Meeting note

Project name	A303 Sparkford to Ilchester Dualling
File reference	TR010036
Status	Final
Author	The Planning Inspectorate
Date	31 May 2018
Meeting with	Highways England
Venue	Planning Inspectorate offices
Attendees	The Planning Inspectorate Susannah Guest – Infrastructure Planning Lead Richard Price – Case Manager Karen Wilkinson – EIA and Land Rights Advisor Michael Breslaw - EIA and Land Rights Advisor The Applicant Will Spencer – DCO and Statutory Process Manager (Highways England) Mark Wilson – DCO Advisor (Arup) Serena Gosden – Assistant Project Manager (MMSJV) Paula McGeady – Lawyer (Burgess Salmon) Julian Bosworth – Lawyer (Burgess Salmon)
Meeting objectives	Feedback on Draft Documents
Circulation	All attendees

TR010036: A303 Sparkford to Ilchester Dualling**Draft documents review**

A303 SPARKFORD TO ILCHESTER DUALLING
WORKS PLANS REGULATION 5(2)(J)
SHEET 1 OF 4

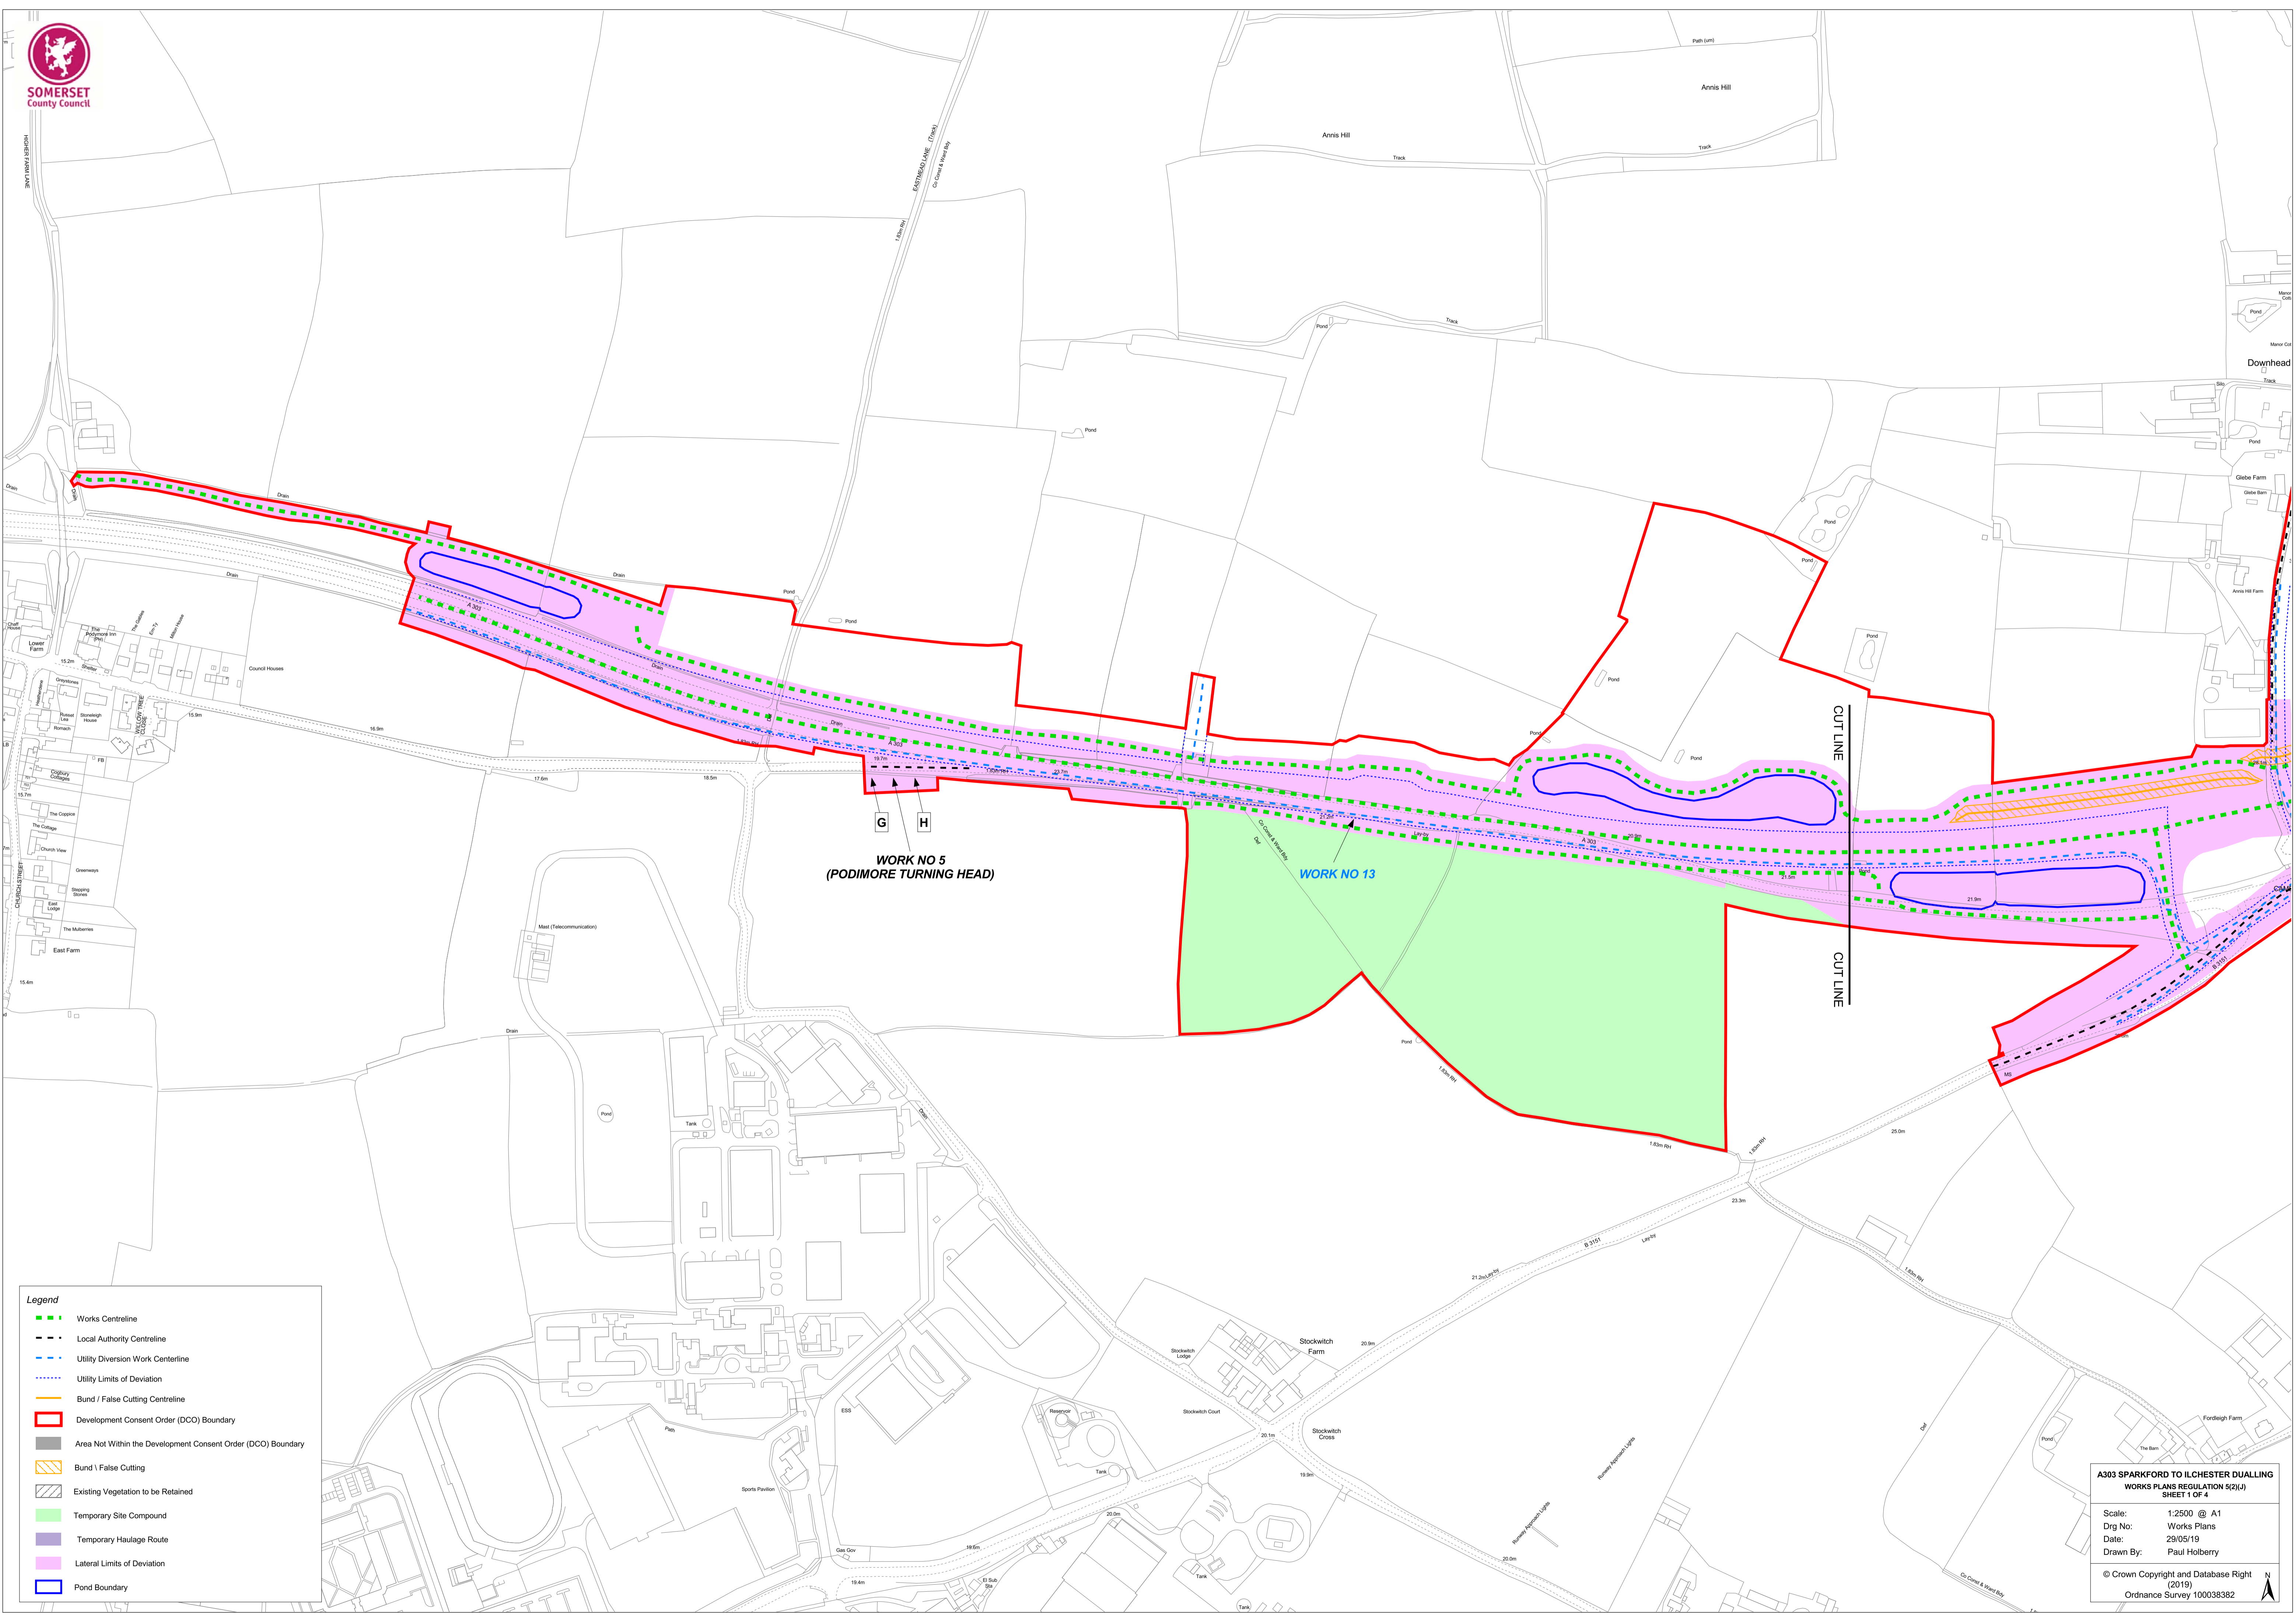
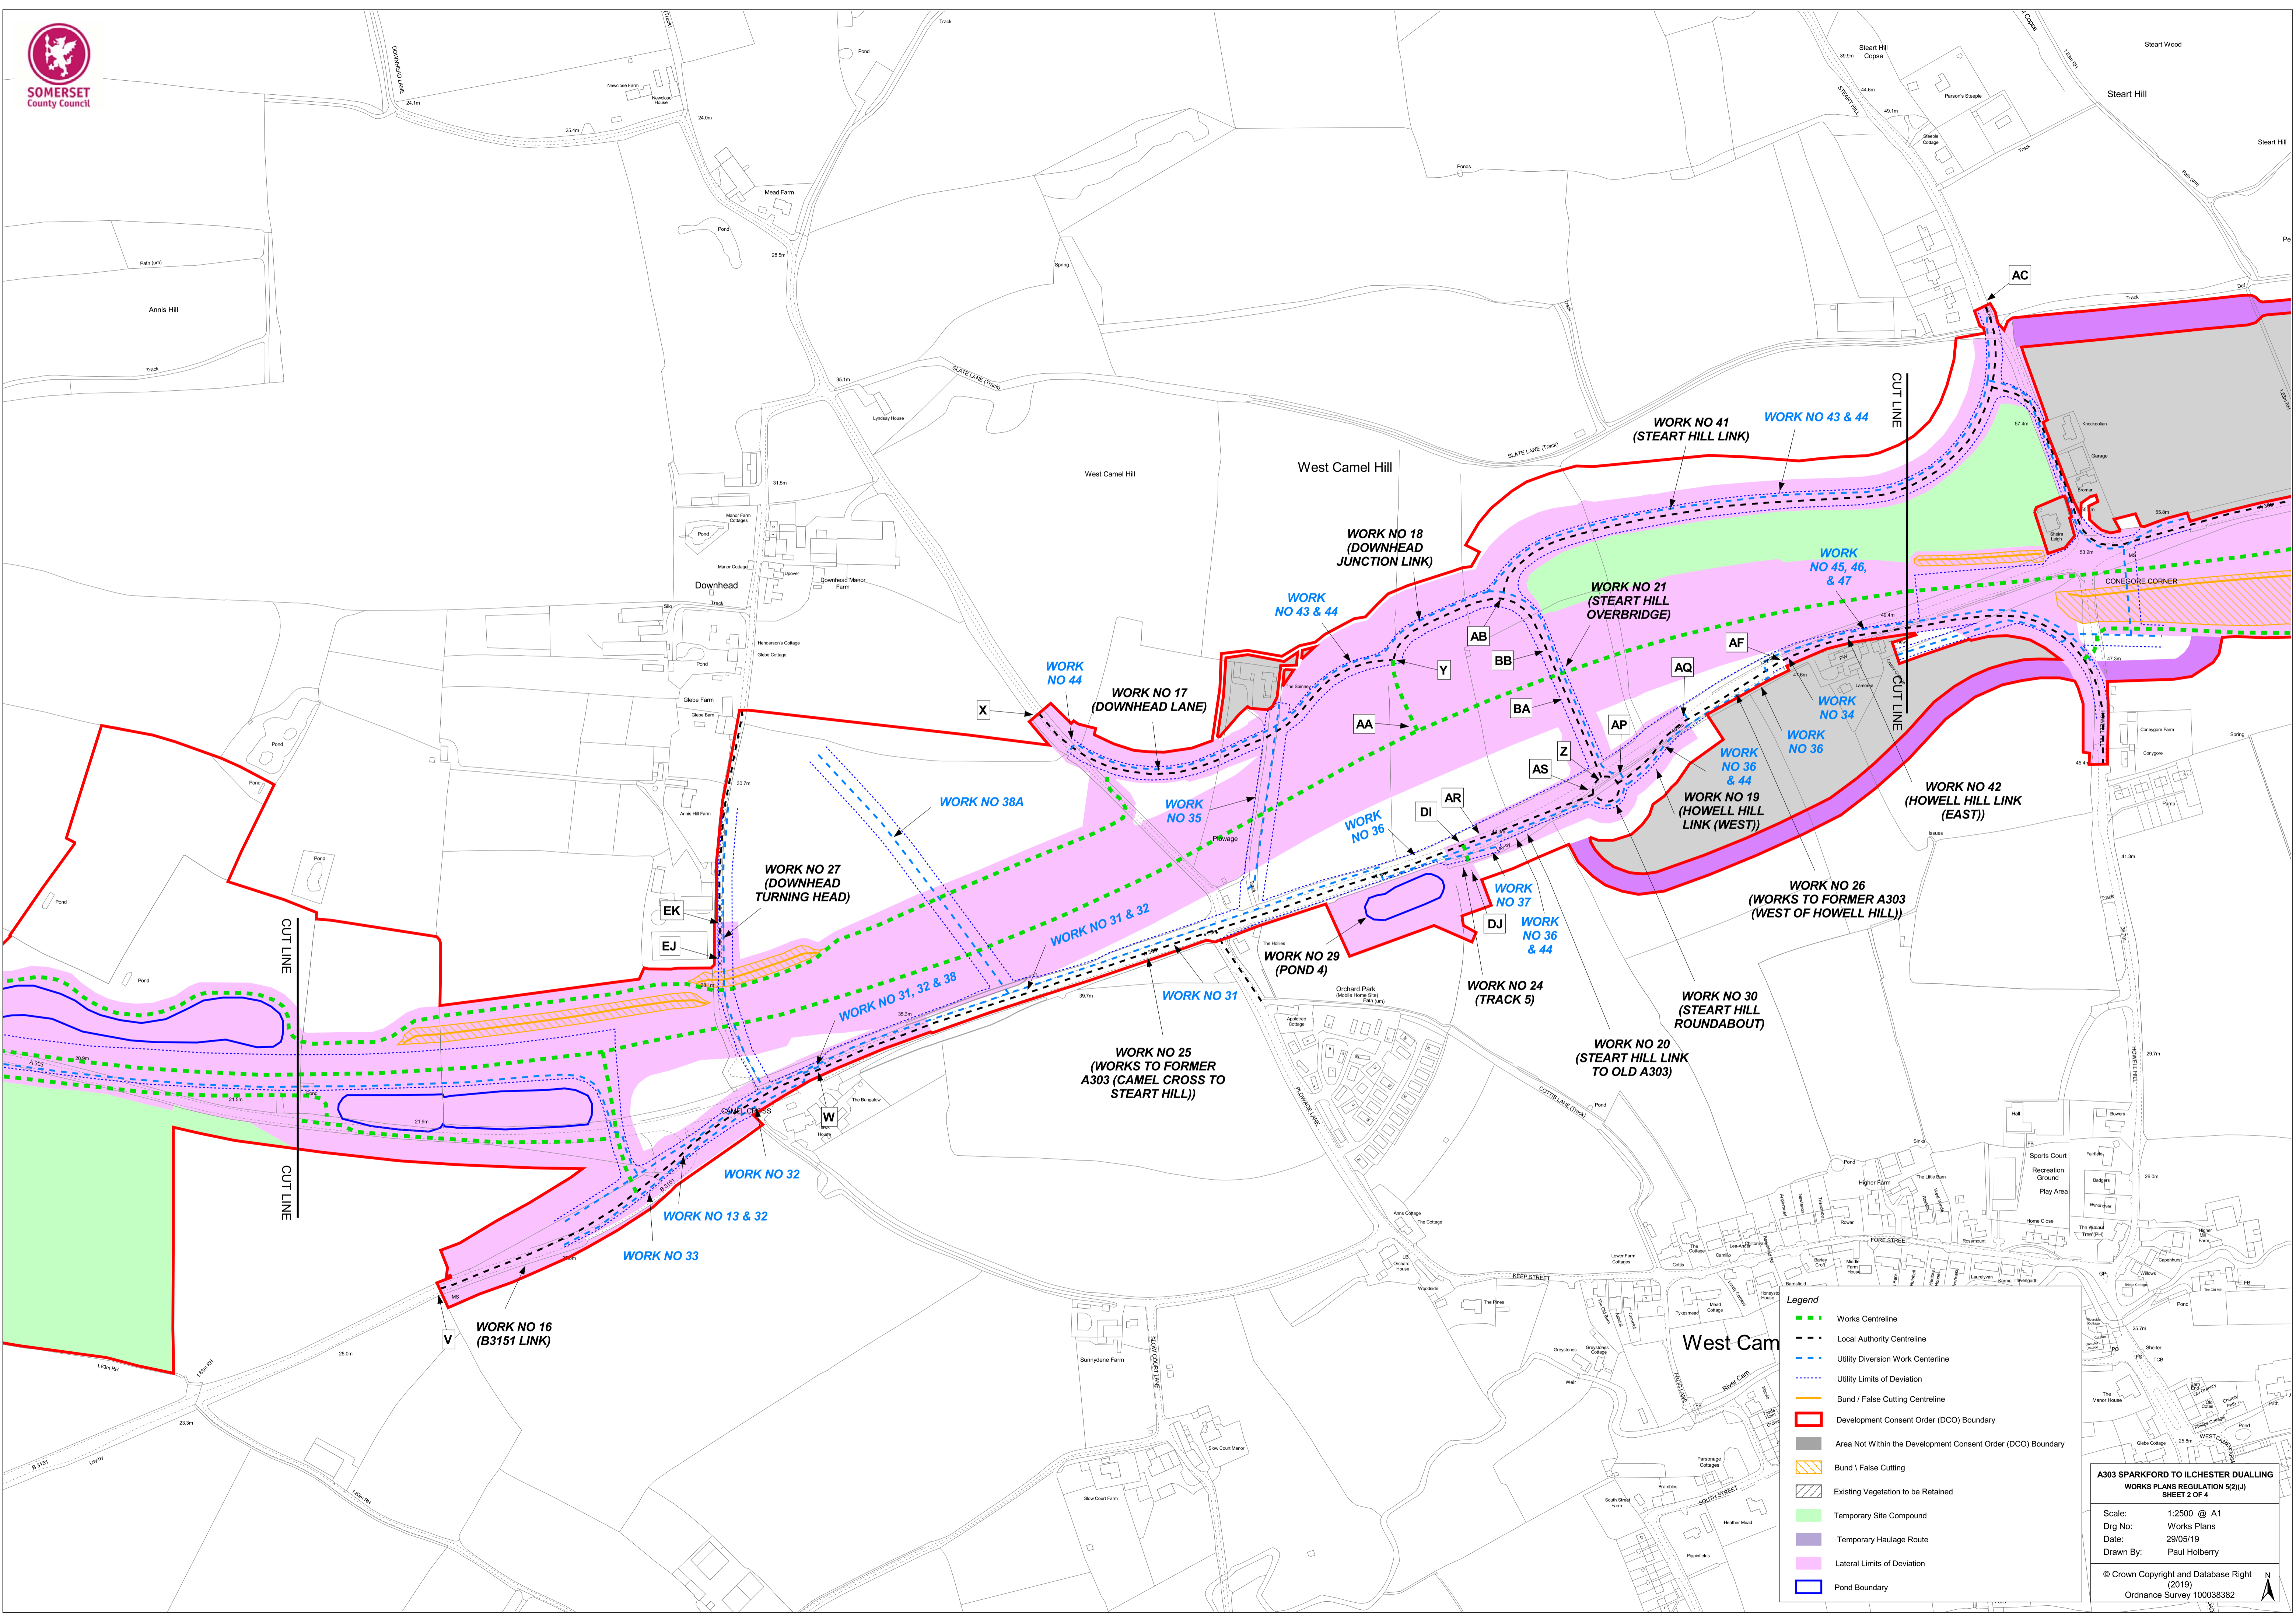
- The works centrelines appear very 'thick'. What meterage do they represent, and how is this reconciled with requisite certainty and the limits of deviation proposed?

- A number of arrows used to identify works either should be extended to meet the relevant works centrelines, or be extended to breach the boundaries of the relevant non-linear works eg Work 7, Work 19.

- In respect of 'ATTENUATION BUND' depictions: is the orange line a centreline?
- On sheet 1, there is an annotation for 'WORK NO.2' that points to an existing overbridge outside of the Order Limits.

- The graphic depiction of the 'DEVELOPMENT CONSENT ORDER BOUNDARY' in the legend is absent.
- In respect of Work 11 and other "*works associated with the retention of existing A30*" eg Work 21, Work 39: what works are they? If they are linear, should there be a centreline between the reference points cited? If not, what are the works boundaries?

- In respect of eg Work 22 and Work 26: 'noise bund' and 'false cutting' are both depicted as 'ATTENUATION BUND' on the Works Plans. Does this provide sufficient clarity?

- In respect of Work 24: in Schedule 1 to the draft DCO it is described as being constructed between reference points 45 and 46. Reference point 45 does not appear to extend to the end of the work as proposed. What is the spur to the east, and should it be described in Schedule 1 to the draft DCO?

- The works numbers are non-sequential eg Work 27 and Work 32 are missing. Will this be explained in the application?
- In respect of Work 38: should Pond 6, whilst an existing attenuation pond, be identified by the same blue line depicting 'ATTENUATION POND BOUNDARY' in the legend.

- In respect Work 44: should reference points be provided in Schedule 1 to the draft DCO?
- Work **45** in Schedule 1 to the draft DCO appears to describe Work **55** on the Works Plans. Should reference points be provided as per comment on Work 44.

- In respect of Work 50: should the second reference point in the description in Schedule 1 to the draft DCO be '83'?
- Work 52 is described in Schedule 1 to the draft DCO as shown on sheets 1 and 2 of the Works Plans. It is not annotated on Sheet 1.

Regarding the Inspectorate's comments on the draft Works Plans (**Annex A**), the Applicant stated that they would be amended to provide greater clarity prior to submission. In respect of the Land Plans, the Inspectorate advised for the Applicant to refer to the Land Plans for the M20 Junction 10a as an example of where a contrasting colour had helpfully been used to depict plot boundaries. The applicant noted the advice but would consider this further on the basis that red plot boundaries are generally standard practice.
